July 14, 2020

JN 16162

Subject: Review of Structural and Civil Drawings
Proposed Ne Shinde Residence
4207 West Mercer Way
Mercer Island, Washington

DETENTION
TANK DETAILS

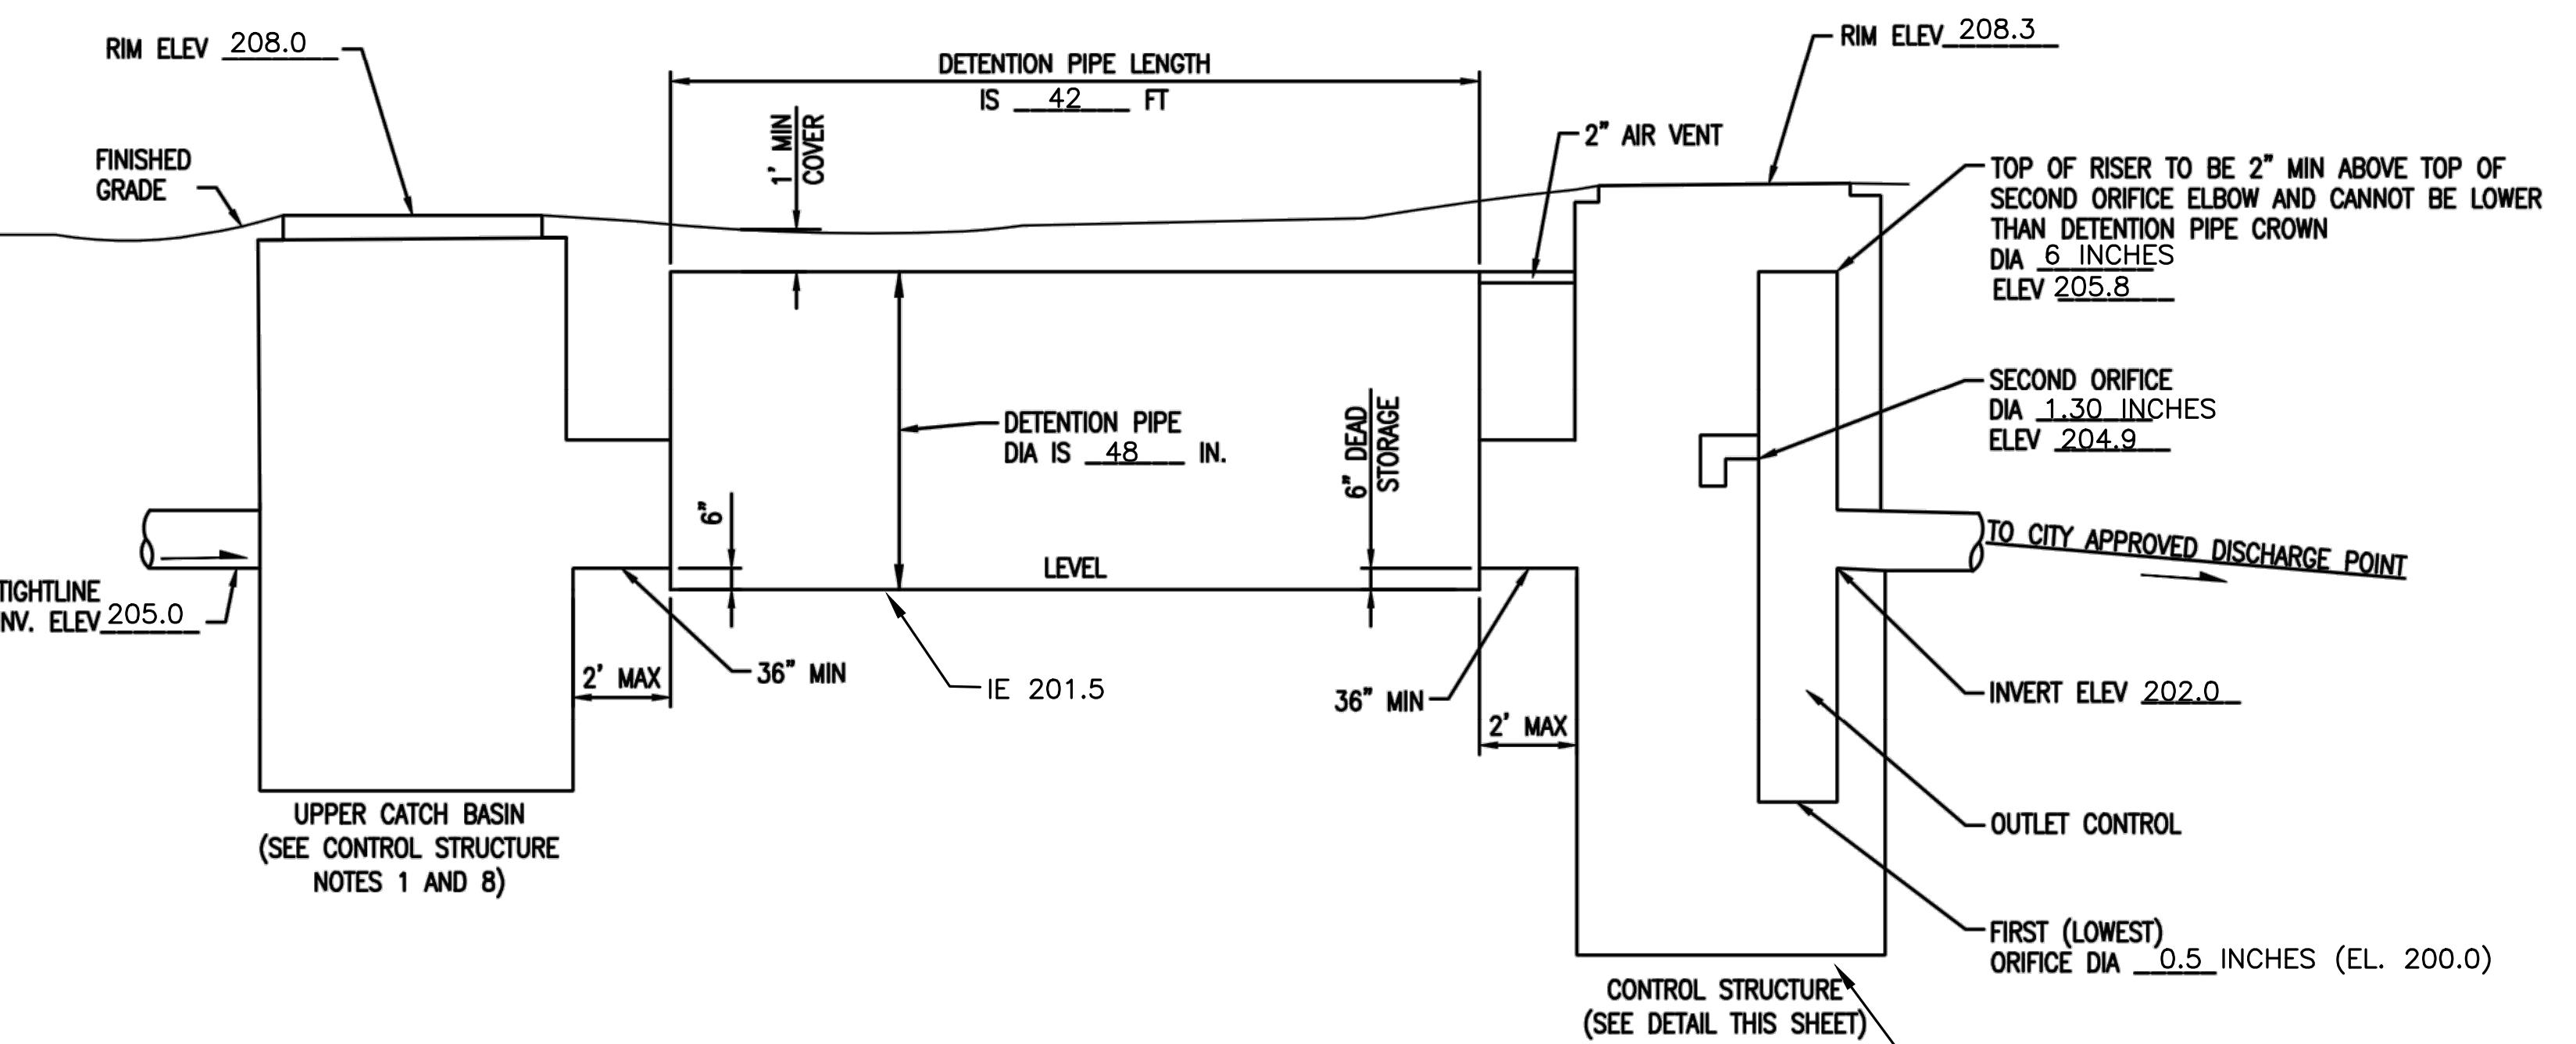
A large detention tank must be installed between the new house and the north property line. It would not be appropriate to install the detention tank closer to the steep slope, as the detention tanks have been known to leak and this would present a risk to the slope. The HDPE outlet for the detention tank will be a flow spreader located at the base of the slope, alongside the watercourse. This is an appropriate discharge point, as the surface runoff from the site currently flows to this point.
